**From:** Patel, Uday <Uday.Patel@lancashire.gov.uk>  
**Sent:** 21 October 2014 14:05  
**To:** planning  
**Cc:** ENV LHS Customer Service  
**Subject:** 3/2014/0791 - Proposed change of use of Ash Tree Cottage to form en suite letting bedrooms - Ash Tree Cottage Downham Clitheroe Lancashire BB7 4BJ

**Planning Application Reference: 3/2014/0791**

**Proposal: Proposed change of use of Ash Tree Cottage to form en suite letting bedrooms**

**Location: Ash Tree Cottage Downham Clitheroe Lancashire BB7 4BJ**

LOCATION PLAN. ASHTREE COTTAGE

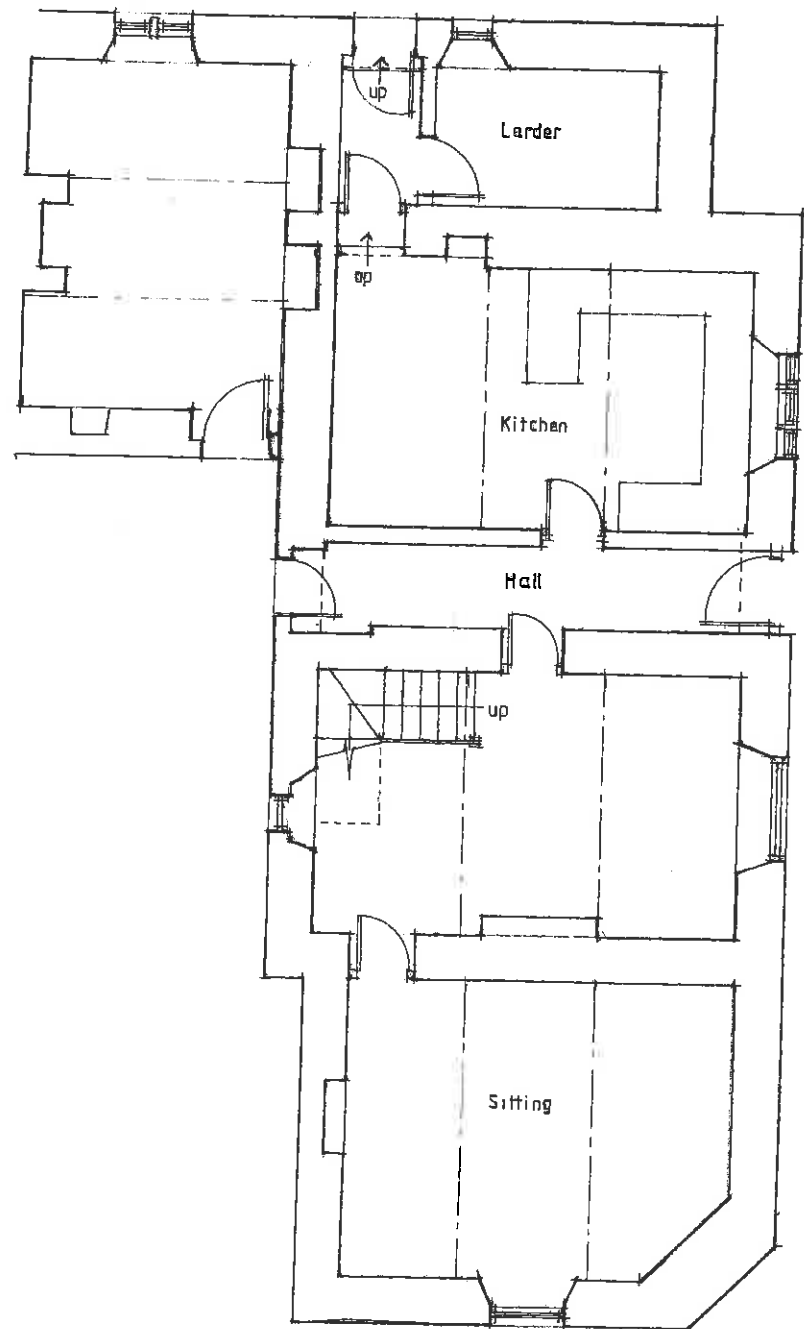
It is recognised that there will be 4no letting bedrooms in the Ash Tree Cottage. There is an existing car park to the North of the Ash Tree Cottage with existing access from East side of the building. Layout plan indicates that car park has a provision of 11 no car parking spaces which includes visitors of the Ash Tree Cottage as well as residents of Ash Tree Cottage. Floor demarcation shall be necessary to identify the parking spaces for the residents as well as for the visitors to Ash Tree Cottage.

Red edge curtilage of Ash Tree Cottage does not include the car park as mentioned above. However, it is noted that car park is bounded with blue edge which suggest that the area is owned by the applicant and thus car park indicated in the layout is available for the visitors of the Ash Tree Cottage as well as residents of Ash Tree Cottage.

There is no objection to the [proposed development on highway grounds.
